Consultation Response from: KC Environmental Health (Pollution & Noise Control)

2025/92614 - Dixon Hall And Co Ltd, Grafton Street, Batley, WF17 6AR

Discharge of details reserved by conditions 4 (noise), 10 (delivery management plan) on previous permission 2025/91841 for variation of condition 2 (plans and specifications) on previous permission 2024/93177 for change of use from office building to residential apartments and associated alterations

Note – These comments relate to Condition 4 (noise) ONLY.

Figure 2 – Measurement Locations and Site Surroundings

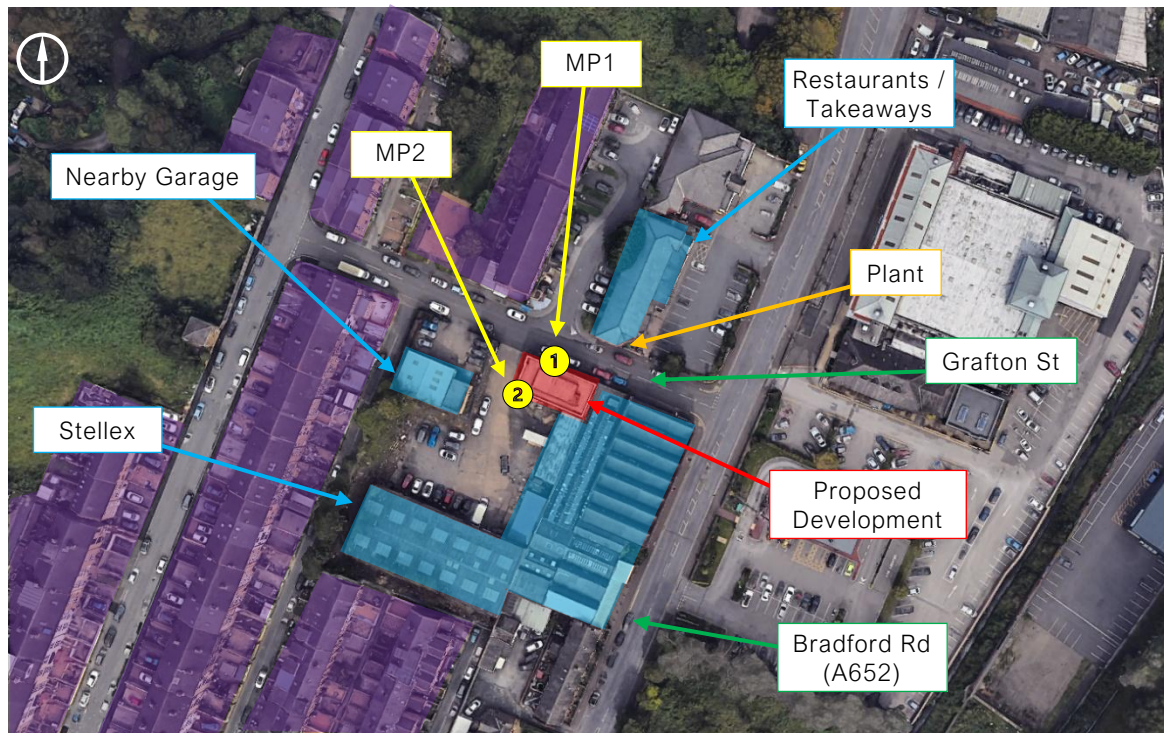
An environmental noise survey was undertaken between the 7th and the 9th of May 2025 from two measurement positions (MPs) as shown in figure 2 and a summary of the findings is given in table 2. The report considers the neighbouring acoustic climate referencing the motor garage, restaurants/takeaways and the applicants adjoining commercial/light industrial premises. Comment is made that during site visits, noise levels within the building were not considered to be significantly influenced by the surrounding commercial activities with occasional operational activity, such as deliveries, observed at the rear of the site. Aside from traffic noise originating from the adjacent road network, no notable noise emissions were detected at the front of the site.

Figure 3 – Façade Allocation – All Floors

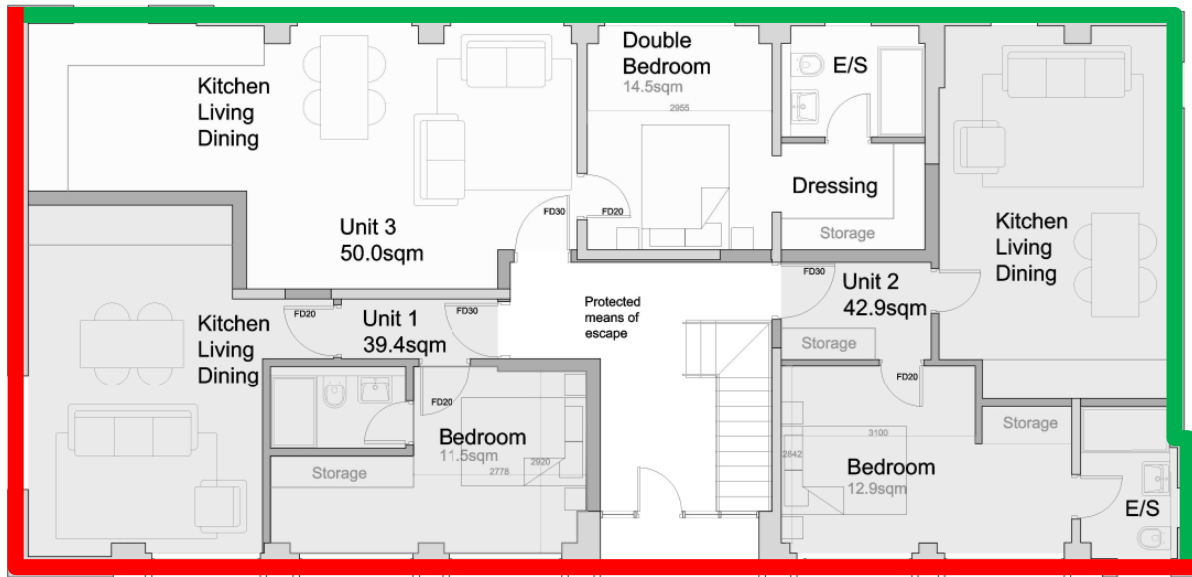
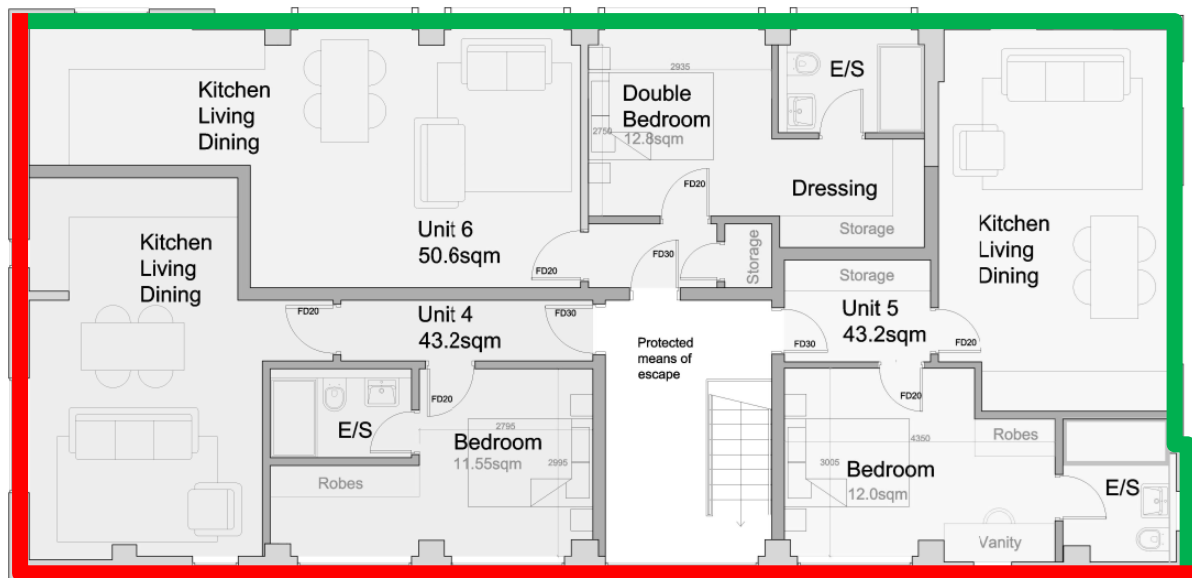
In order to meet with the internal requirements of BS8233, glazing and ventilation is specified dependent on the façade and this is shown in colour coded format in figure 3. The specification is given in table 4.
